Transport
Roads & Traffic
Authority

**MIXED USE RESIDENTIAL, RETAIL AND COMMERCIAL DEVELOPMENT
330 CHURCH STREET, PARRAMATTA**

20 September 2011

PROJECT
RIVERFRONT APARTMENTS
330 CHURCH STREET
PARRAMATTA NSW
DRAWING NAME
Plan_Parking Level 04

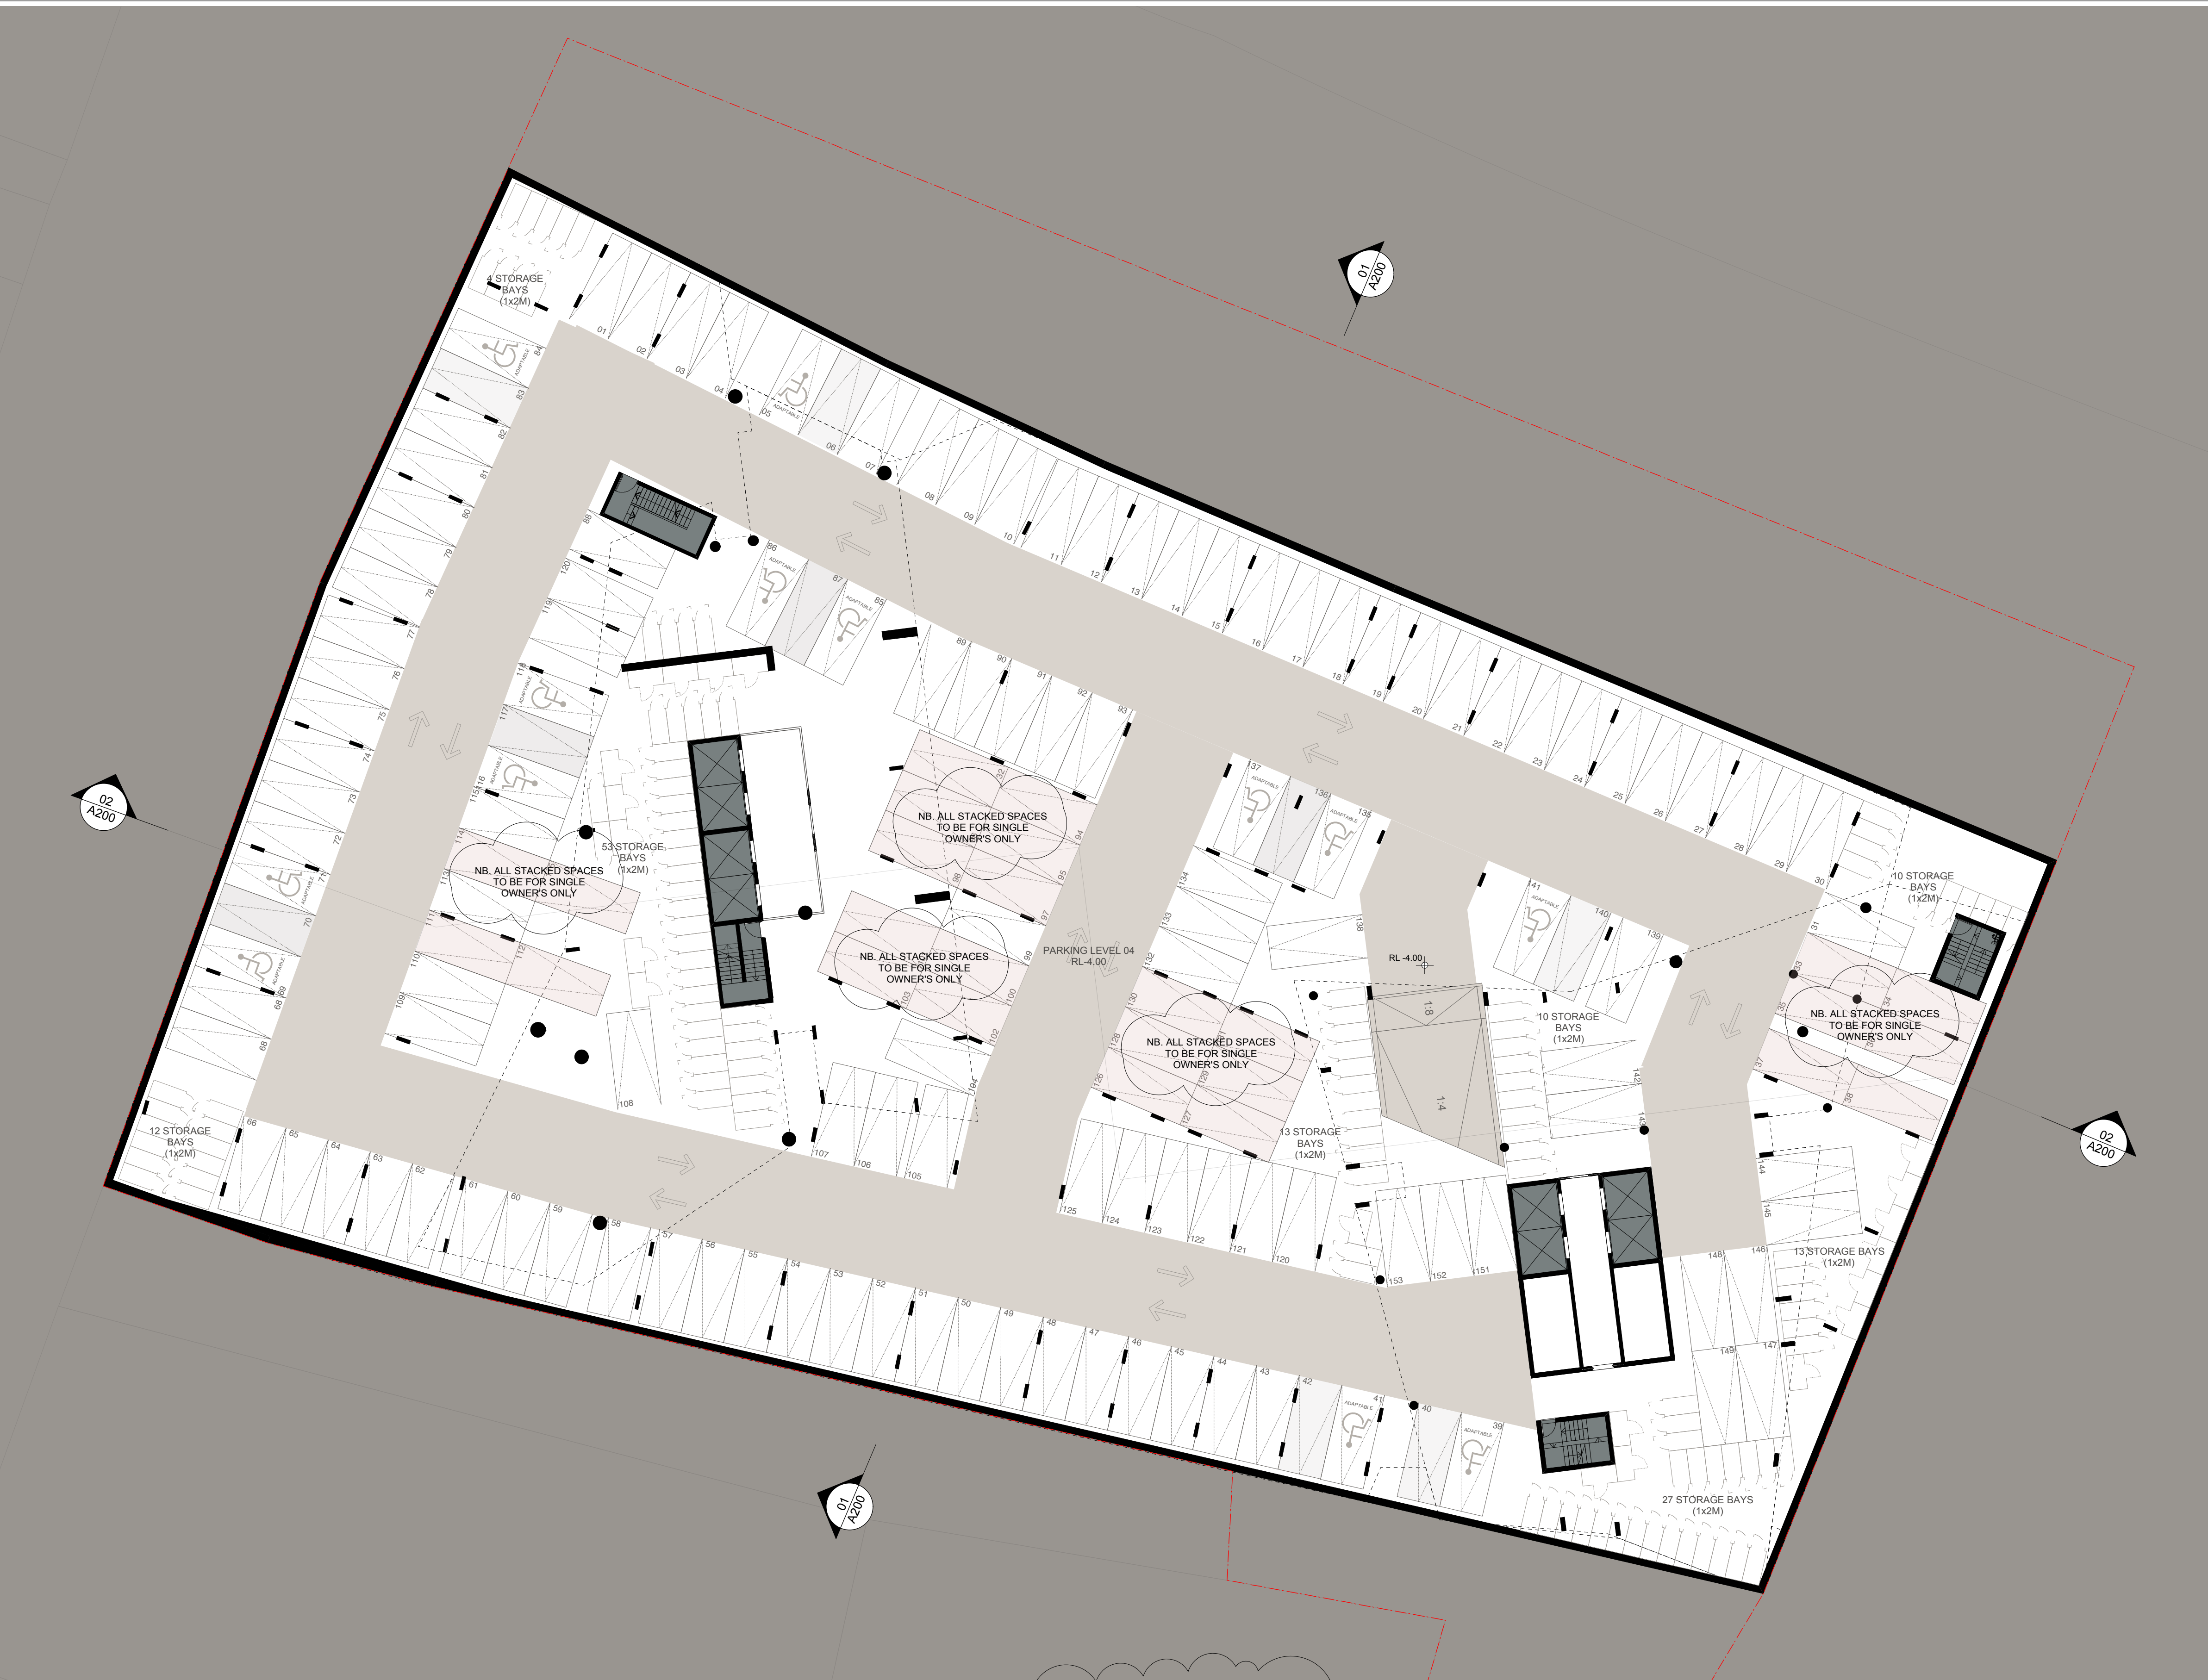
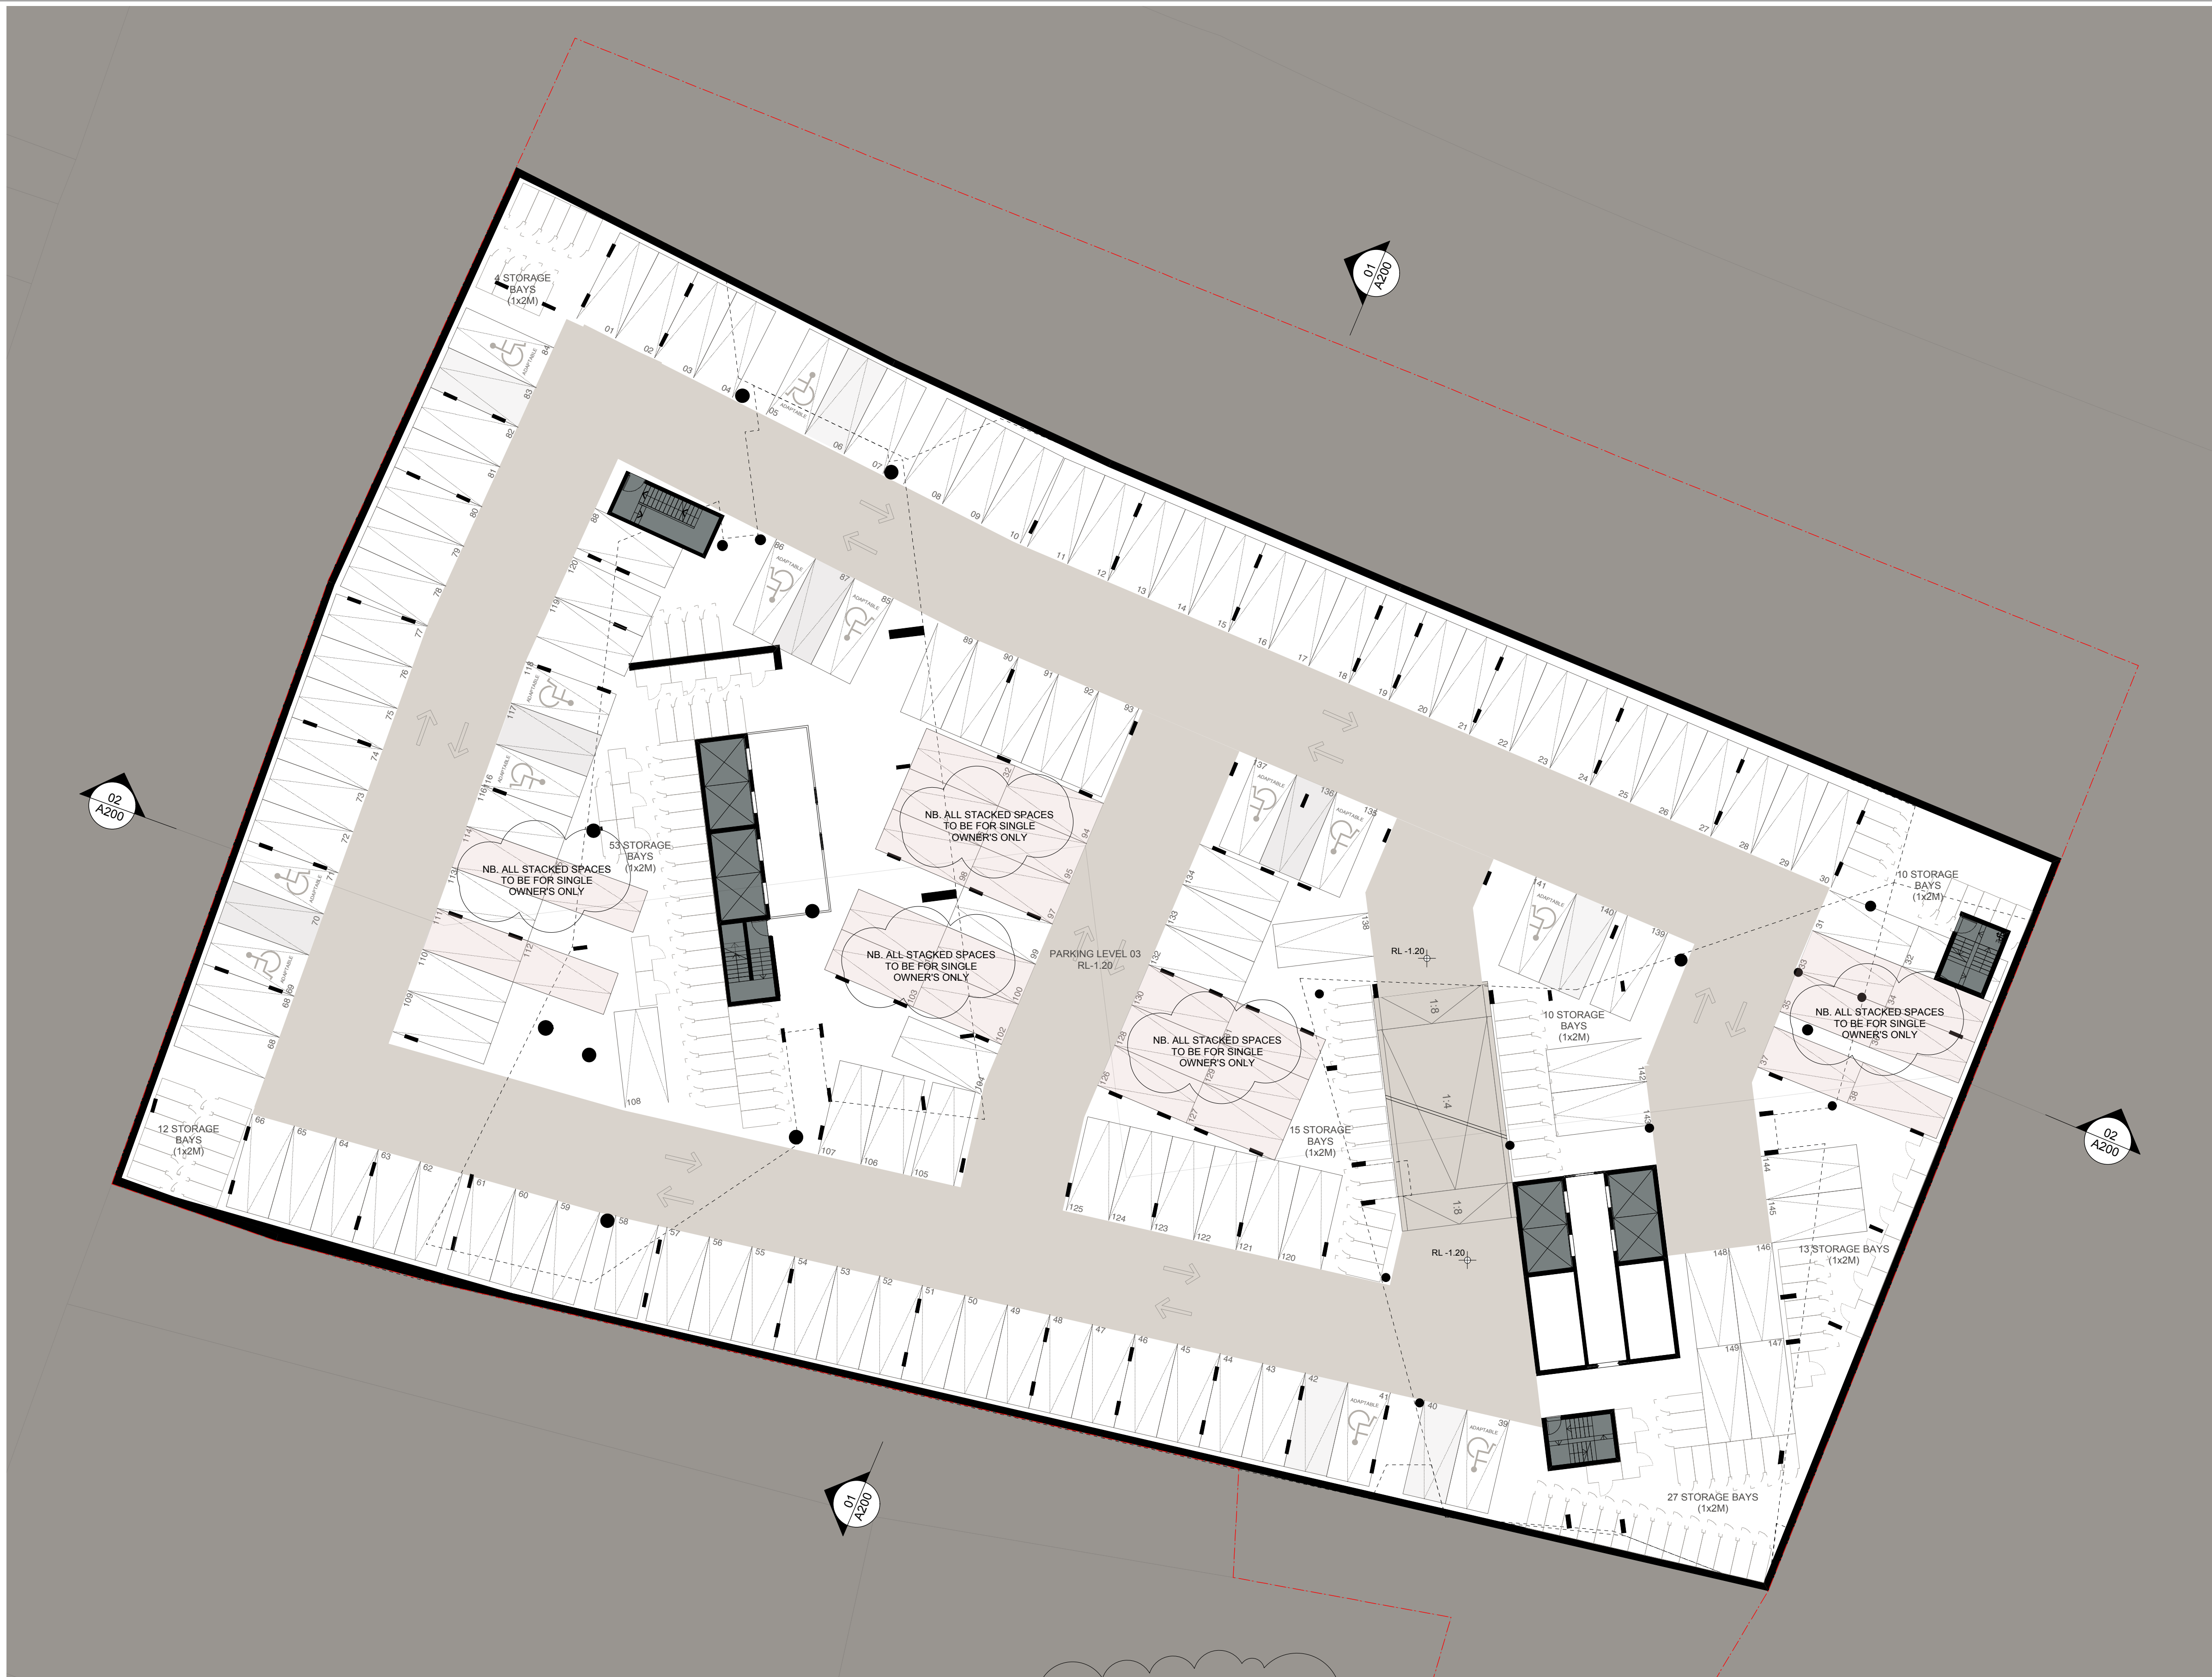
2. It is noted that one car parking space per unit is proposed as part of the development and a number of parking spaces within the basement carpark are stacked. It is not practicable to use stacked parking spaces when only one space per unit is allocated. It is suggested that stacked car parking spaces are removed. The RTA will support providing less number of parking spaces at this location to encourage the use of sustainable transport.

3. No bicycle parking spaces are provided as part of this development. It is recommended adequate and convenient bicycle parking facilities are provided within the development.
